Our ref: OUT22/11819

2 September 2022

Subject: **Dalswinton Quarry (SSD-9094) - Response to Submissions (RtS)**

### Detailed advice to DPE Planning & Assessment regarding the Dalswinton Quarry (SSD-9094) - Response to Submissions (RtS)

**FIGURE 3.2**  
Existing Water Management System Schematic

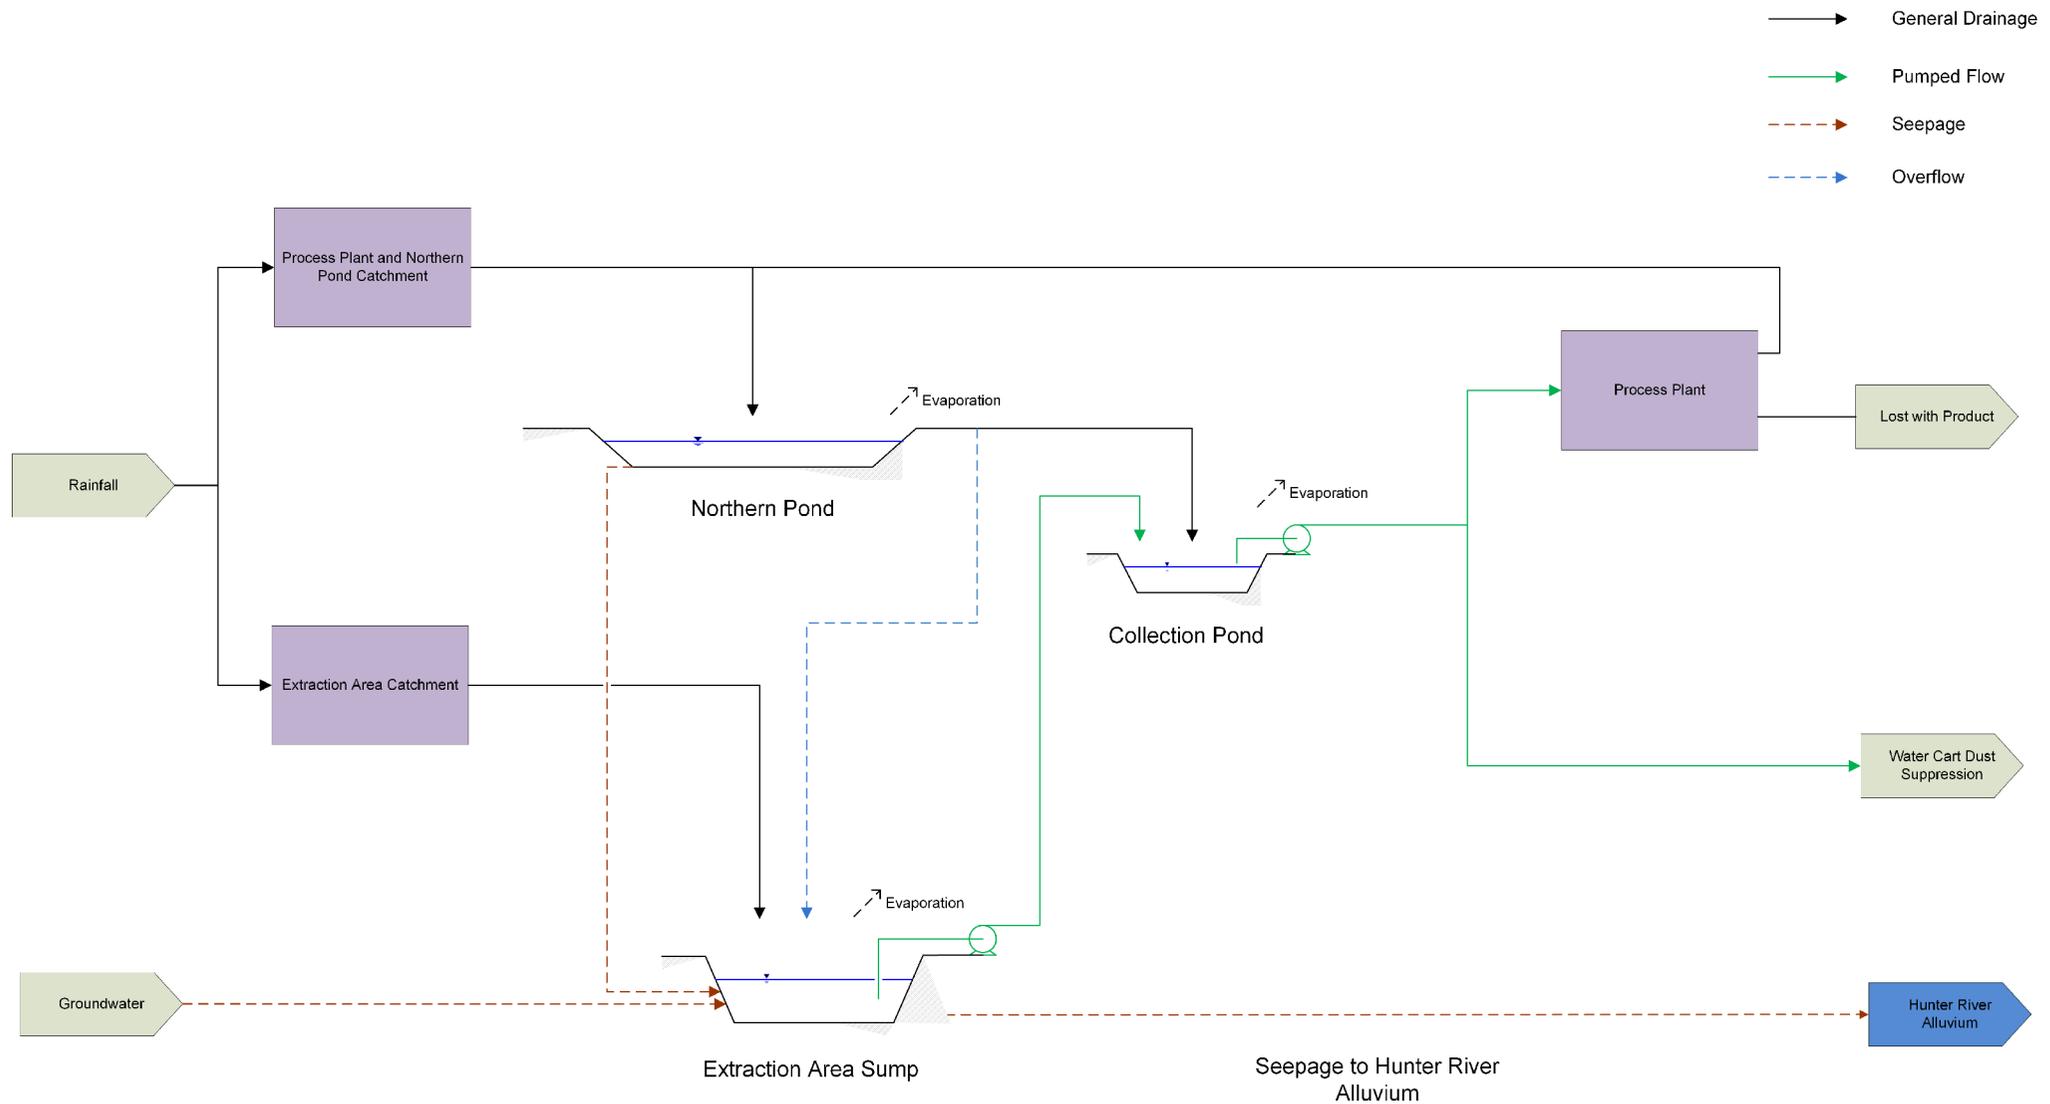
- As noted in Figure 2 – Existing Water Management System Schematic found in Appendix D – Letter Surface Water Impact Assessment groundwater will seep into the Extraction Area Sump and seepage from the Hunter River will be occurring, these are both classified as take.

The proponent must ensure sufficient water entitlement is held in a Water Access Licence/s (WAL) to account for the maximum predicted take for each water source prior to take occurring, unless an exemption under the Water Management (General) Regulation 2018 applies.
